# KIRKLEES METROPOLITAN COUNCIL INVESTMENT & REGENERATION SERVICE

### DELEGATED DECISION TO DETERMINE PLANNING APPLICATIONS

| Reference No:         | 2023/62/93352/E                                                          |
| Site Address:         | 84, Soothill Lane, Soothill, Batley, WF17 6NB                            |

Drawing Number 23-108 - P - 02 - A

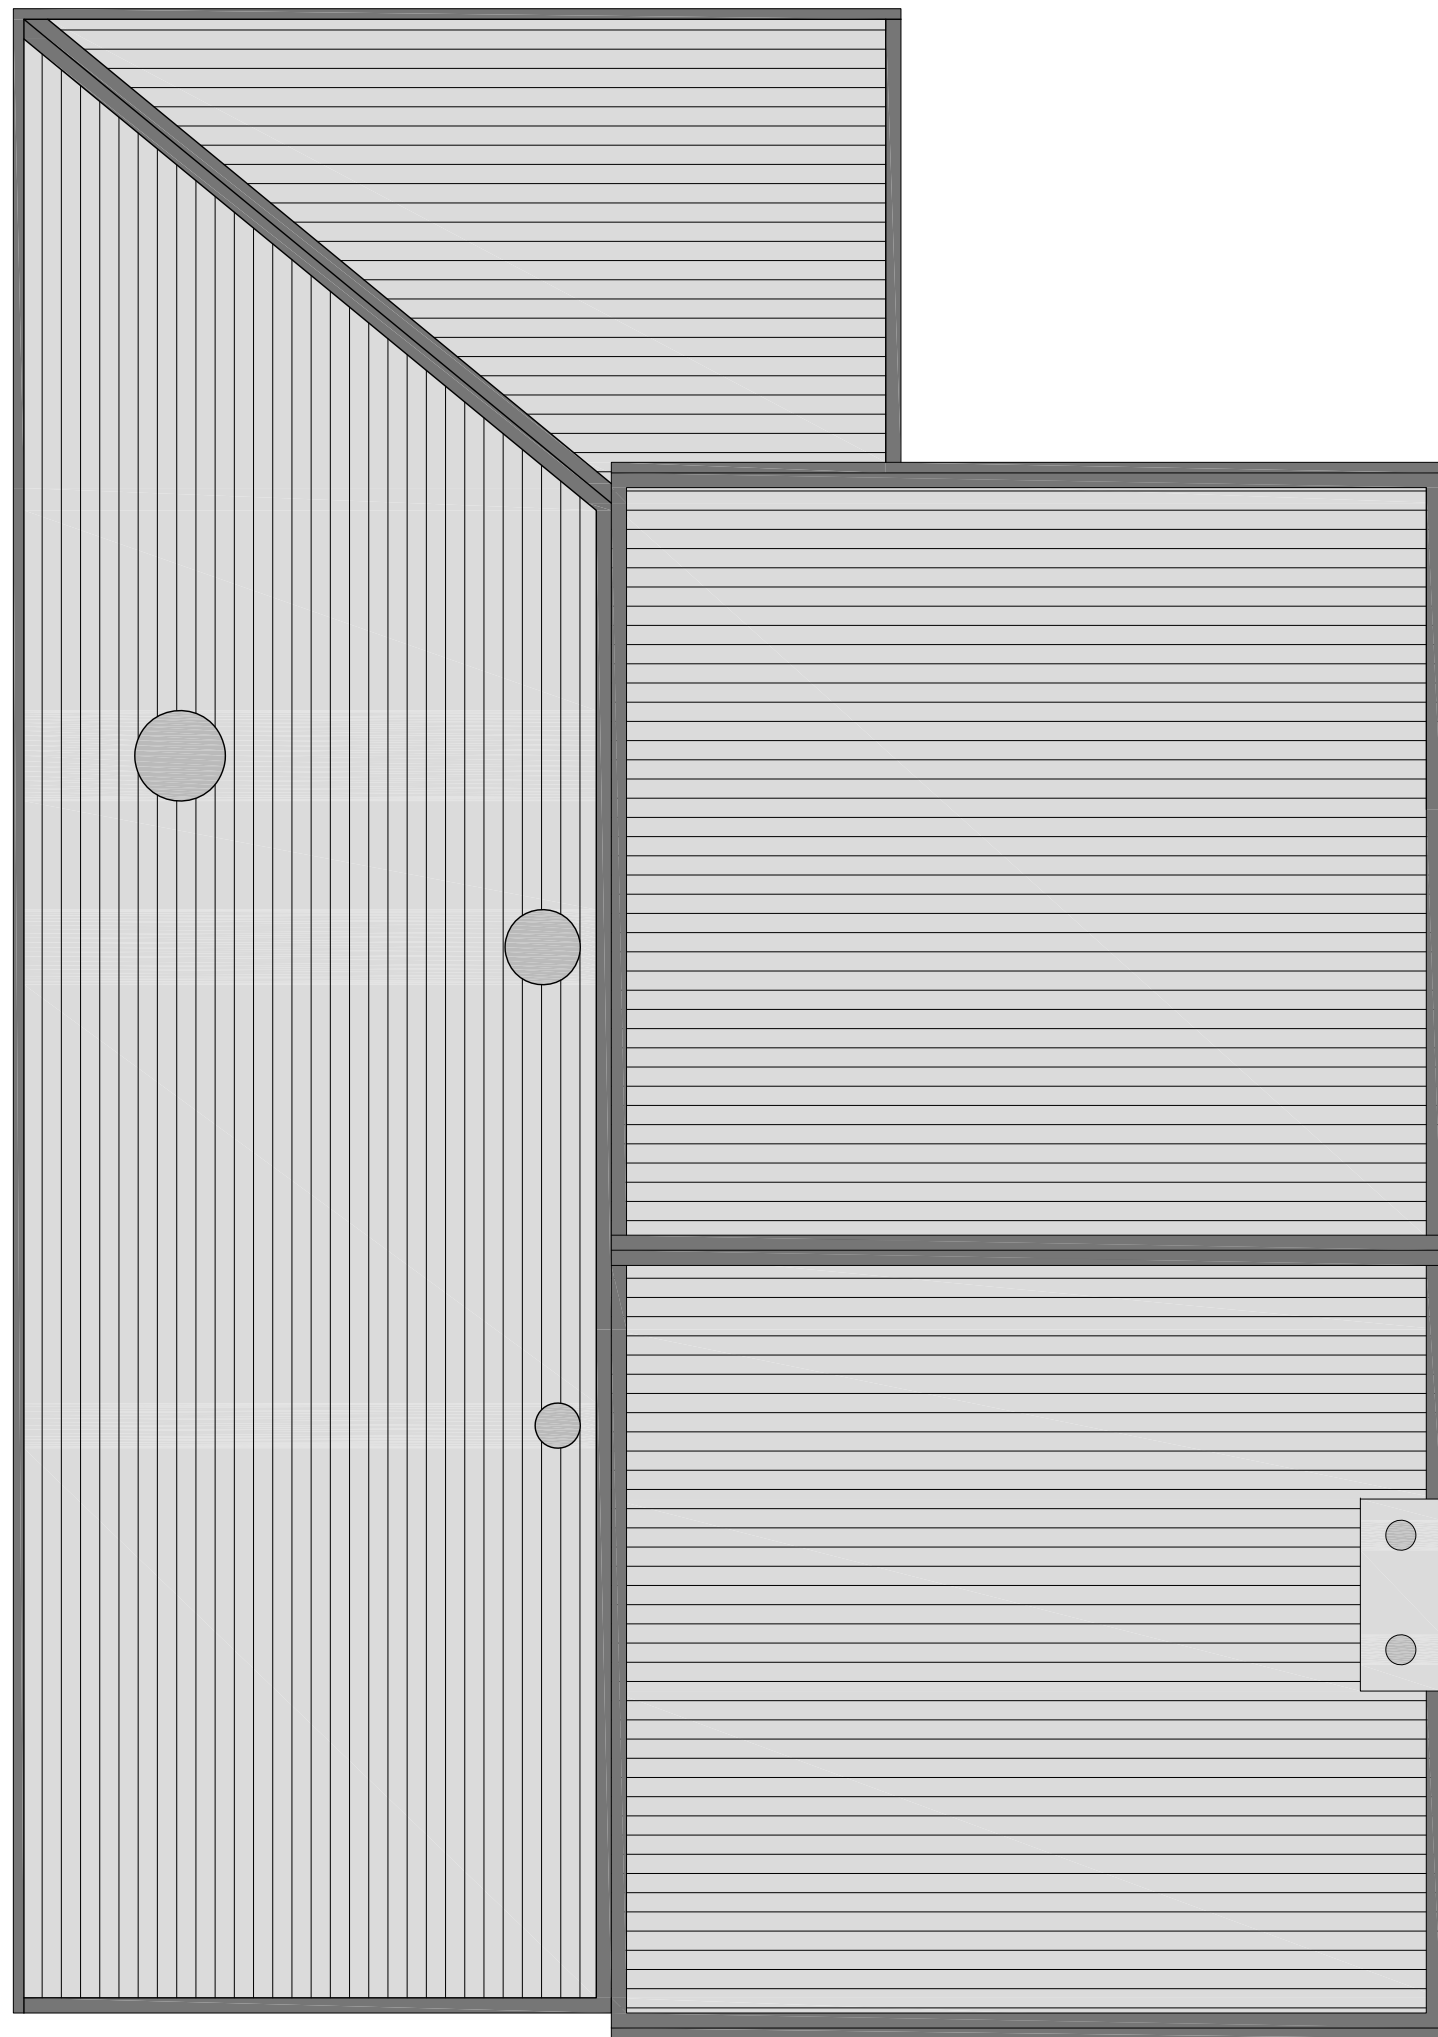
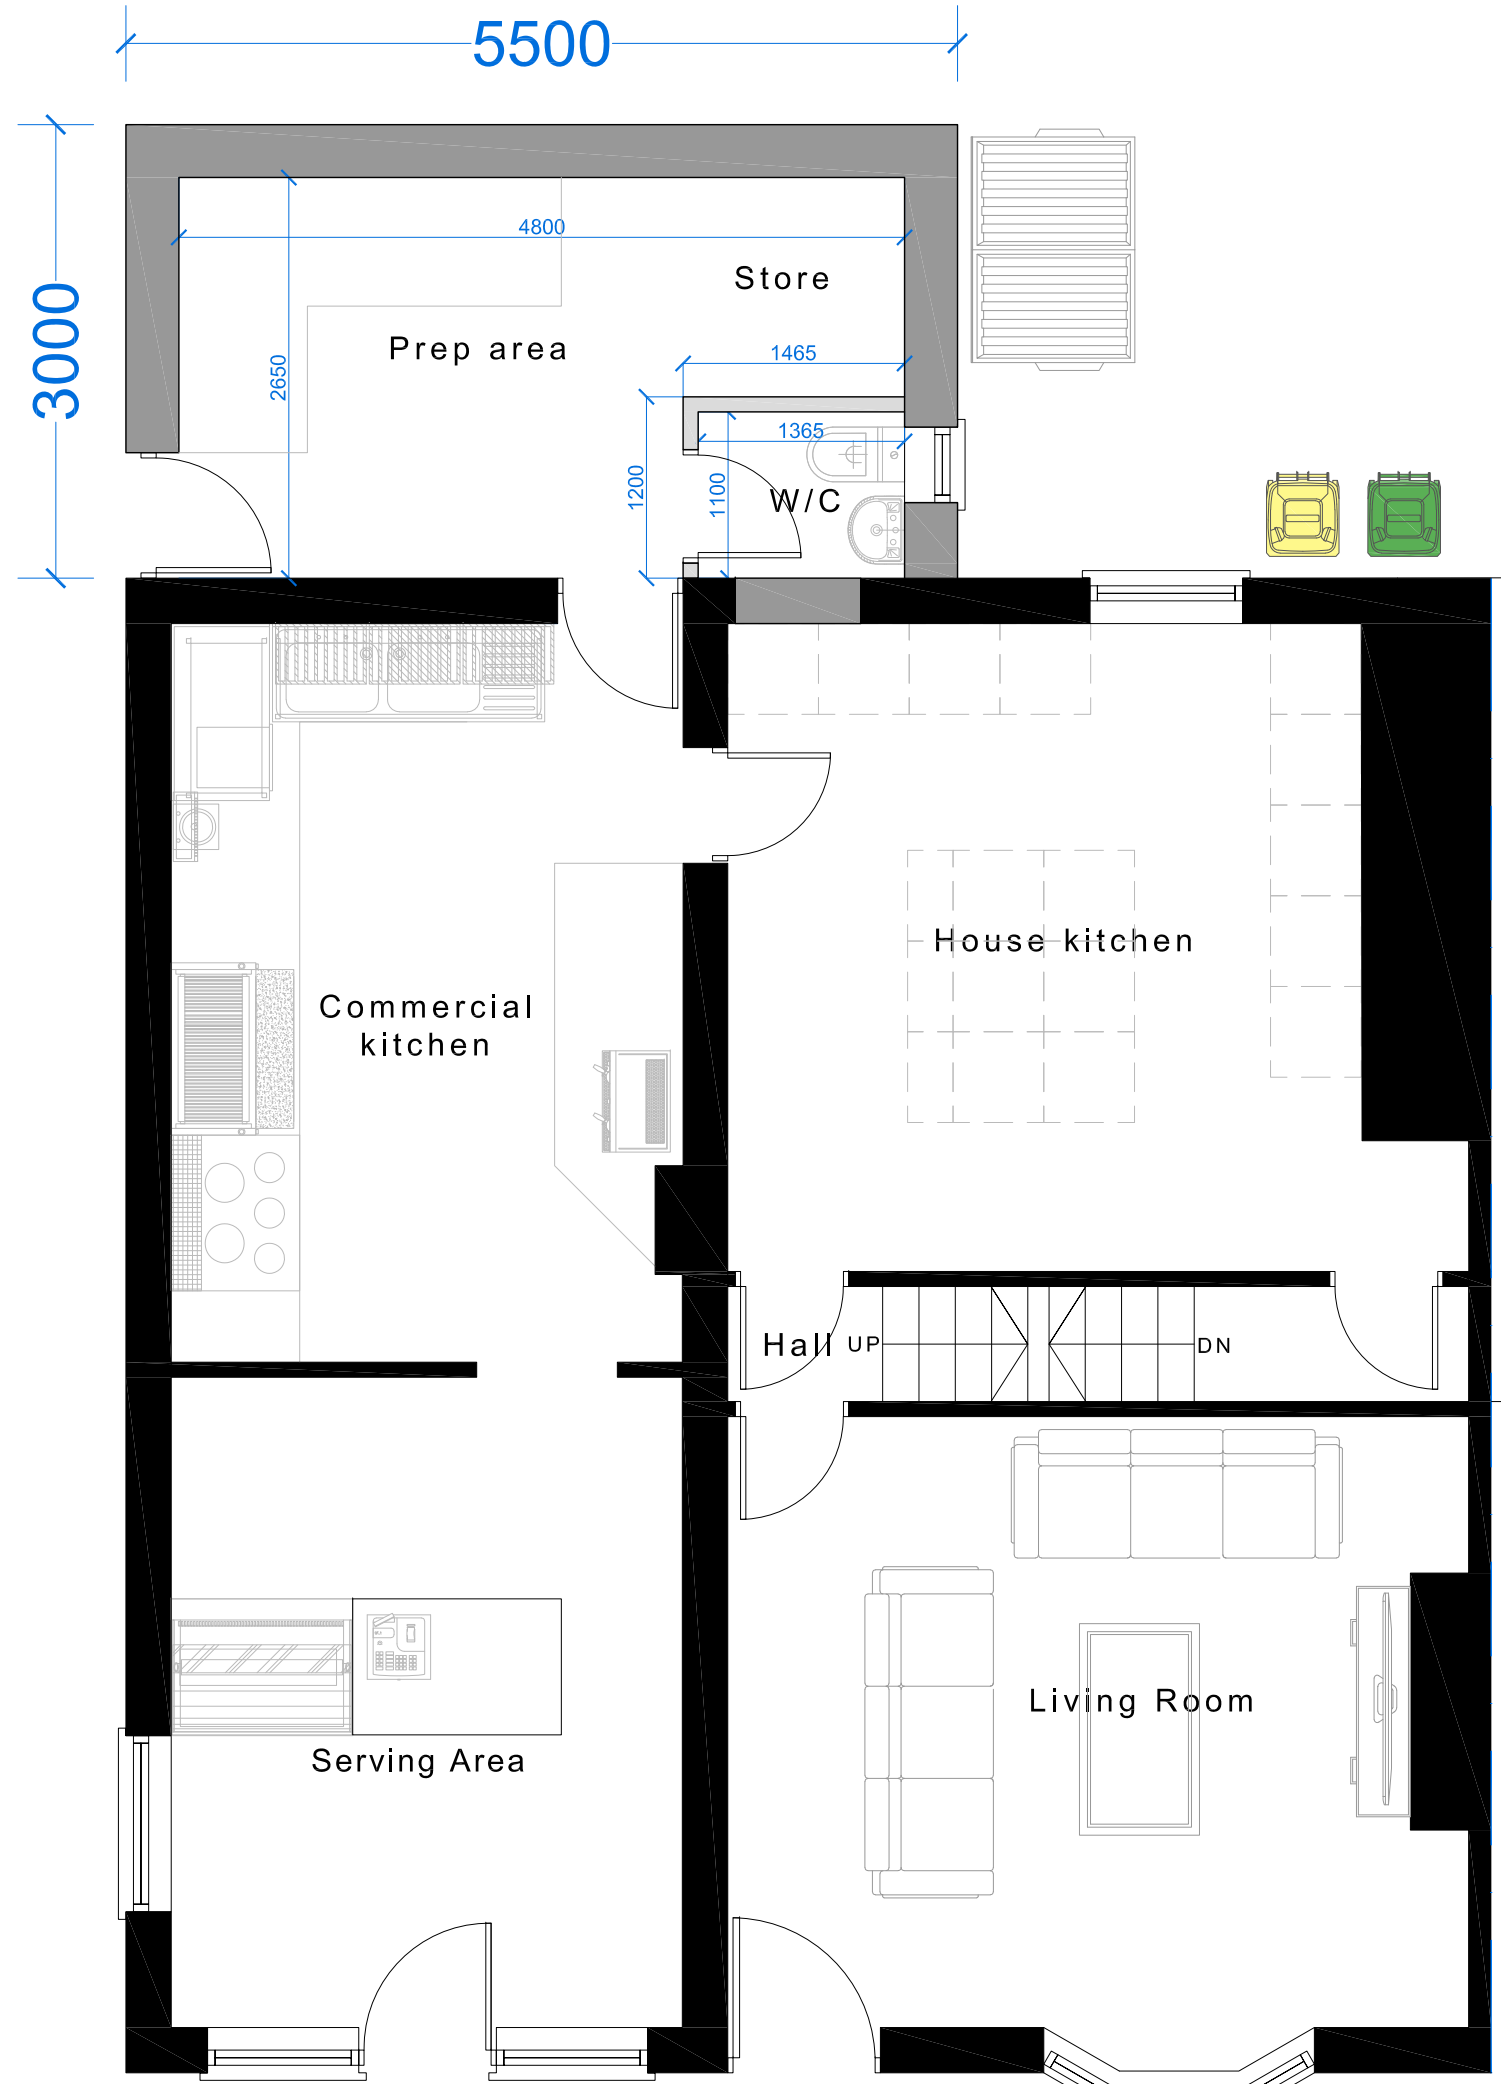
the extension is a rear extension with a temporary appearance which will be removed to allow for space for the extension. There are currently no rear windows on the ground floor of the building. The removal of such will improve the amenity of occupants at 84 Soothill Lane through the forming of a window. The extension will project past the 'house kitchen' window with a gap of ~0.85m. In this instance, the introduction of a rear window will improve the living conditions of the rear room by allowing light into area. The extension will contain a W.C area, in order to protect the privacy of the occupants of the dwelling area, the W.C window will be conditioned to be obscurely glazed.

82a Soothill Lane is the adjoining semi-detached dwelling to the west of the application site. In terms of privacy, the W/C window will face towards the property. It will be conditioned that the window will be obscurely glazed to prevent any detrimental impact to privacy. There will be a distance of ~4.10m from the extension to the property boundary, as the extension is single storey with a large gap to the property maintained, there will not be a loss of light, outlook or an overbearing effect from the extension.

4. The development shall not be occupied until the W/C window on drawing 23-108-P-02 of the extension hereby approved has been obscurely glazed (to a minimum Grade 4). Notwithstanding the provisions of the Town and Country Planning (General Permitted Development) Order 2015 as amended (or any Order revoking or re-enacting that Order) the obscure glazing (to a Grade 4) shall thereafter be retained.

Drawing Number 23-108 - P - 03 - A

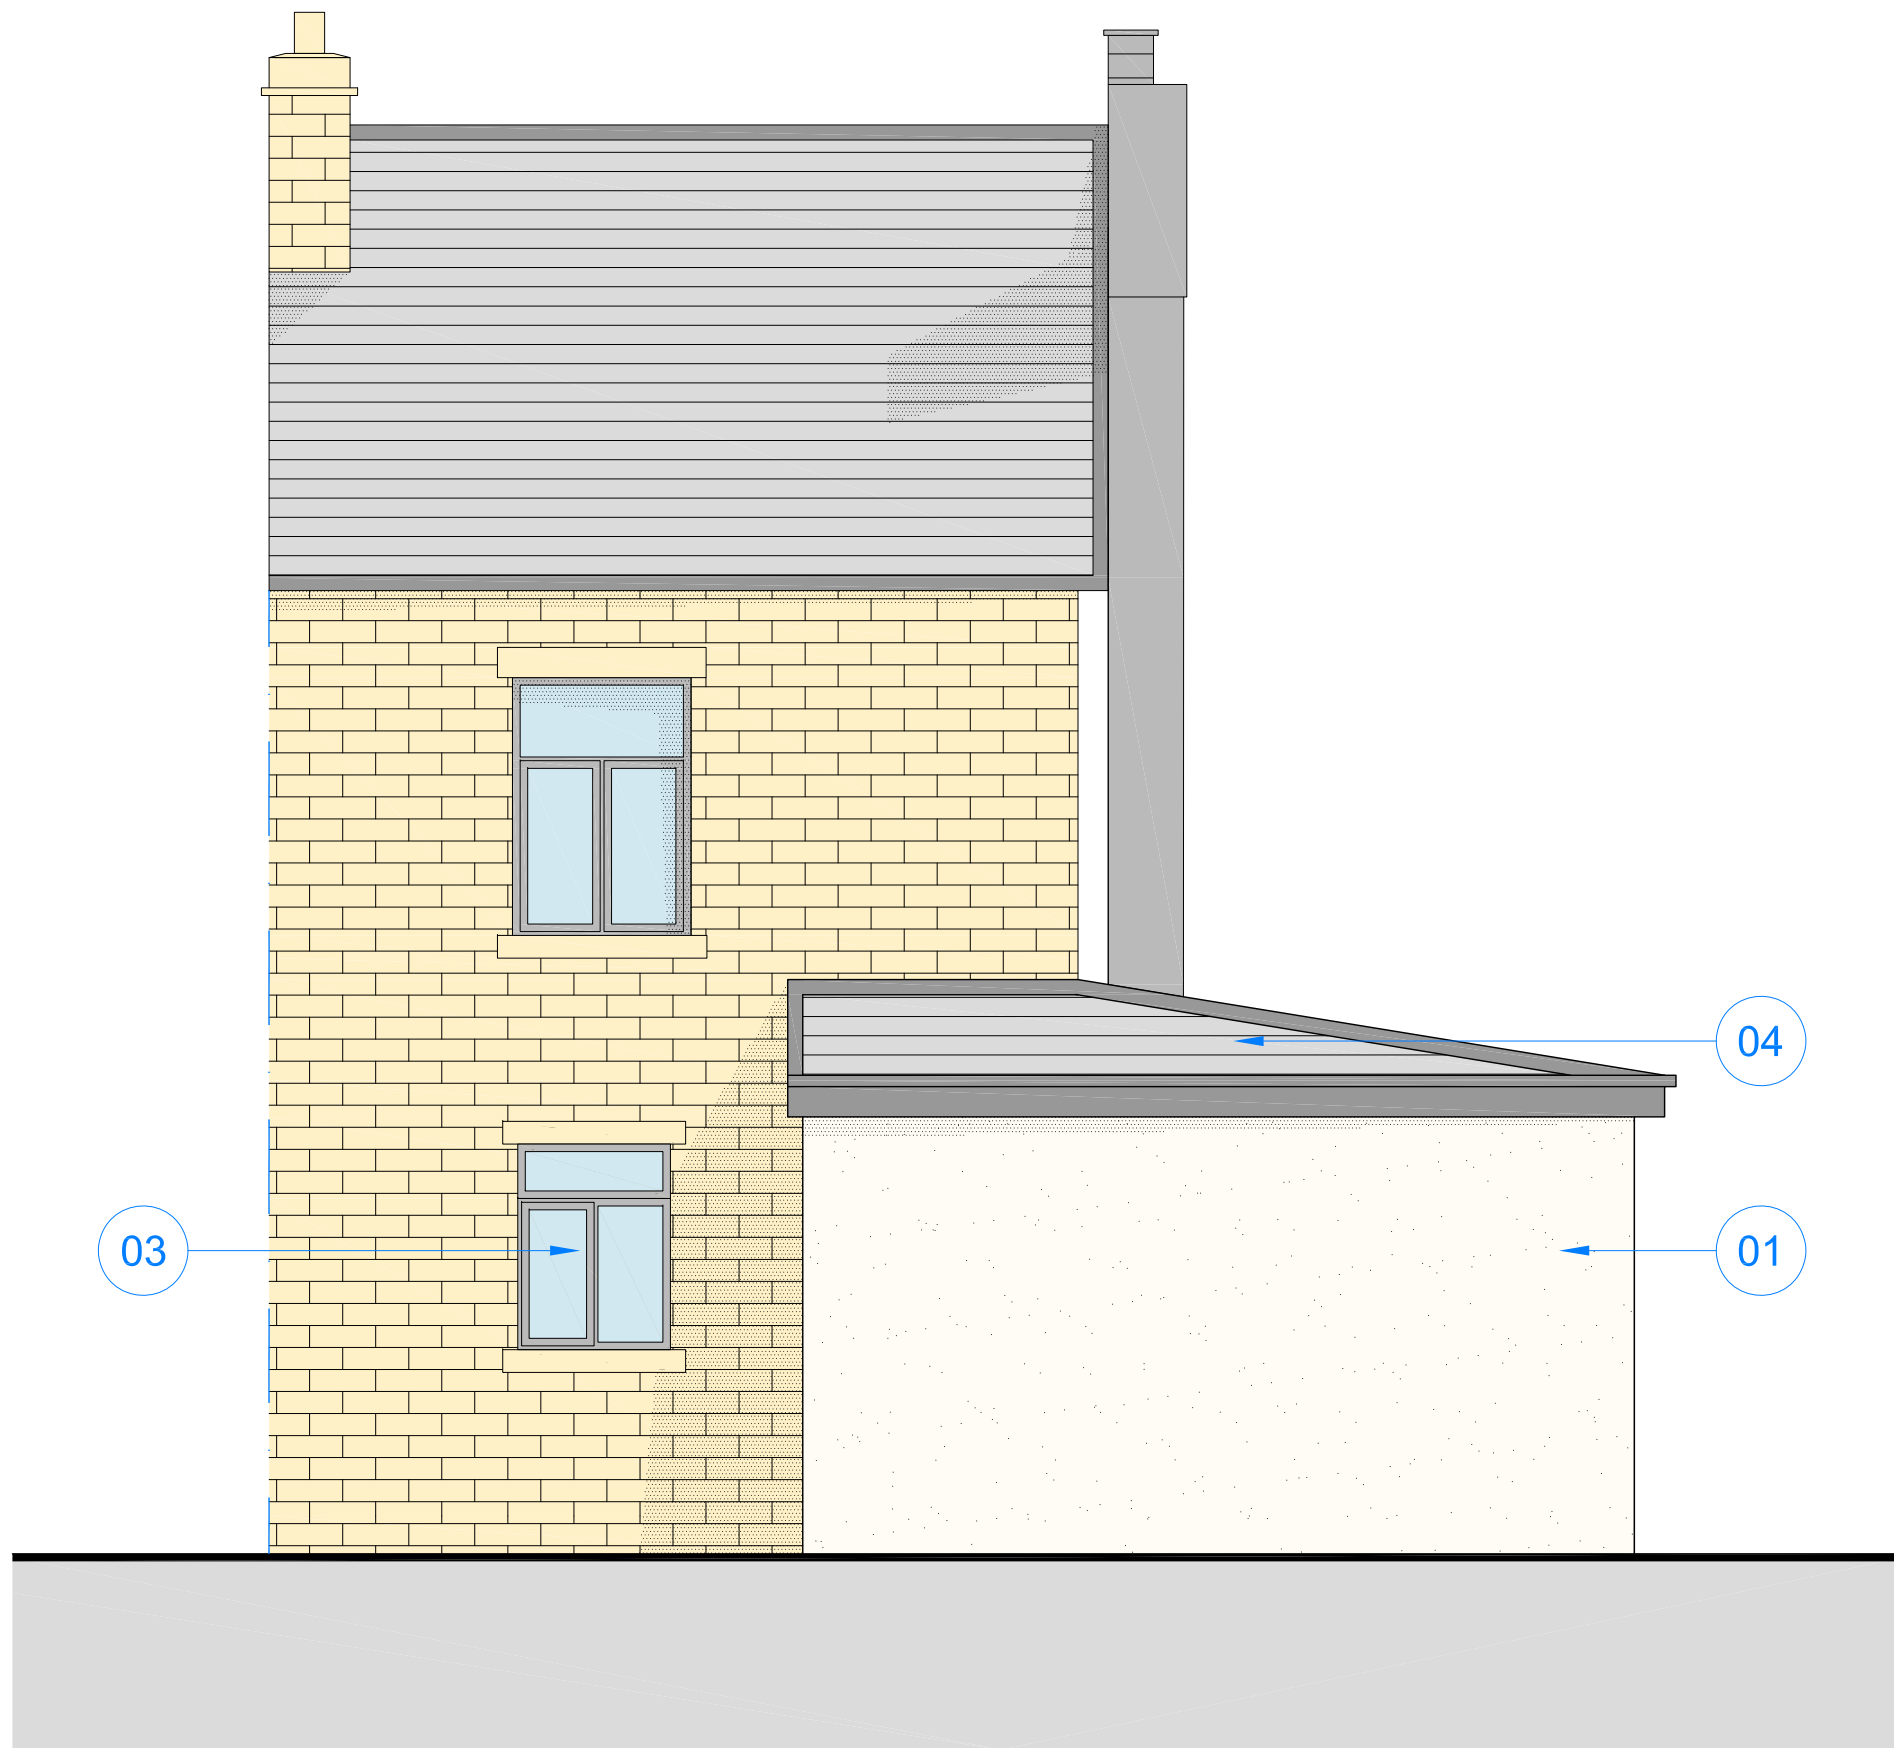
Takeaways in residential areas should be sympathetic to their surrounds, by being complimentary to the surrounding building group in terms of scale and appearance. The extension will be to the rear and side of the building but will be visible when travelling down Brentwood Close, a residential street. The application site shares its boundary with a shared space which is occupied by garages that are owned by residents of Brentwood Close. Through the choice of building materials and height of the structure, the extension will not appear incongruous when considered in context with the residential dwellings and garages that are in close proximity to the site. Additionally, the extension will form a 'wrap around' of the original building which, in terms of visual appearance to the dwelling, complements its later additions. The proposal is therefore acceptable in terms of impact to visual amenity.

4 Brentwood Close is situated to the south of the application site and is approximately ~11.60m from the extension. There will be one habitable window introduced which will face towards the property. In terms of this, there are garages between the two properties which will partially obscure the view, additionally there are no openings on the side elevation of 4 Brentwood Close. The relationship is therefore acceptable in terms of impact to privacy. Due to distance, there will not be an overbearing impact, loss of light or loss of outlook.

3. The external walls and roofing materials of the extension hereby approved shall in all respects match those used in the construction of the existing building.
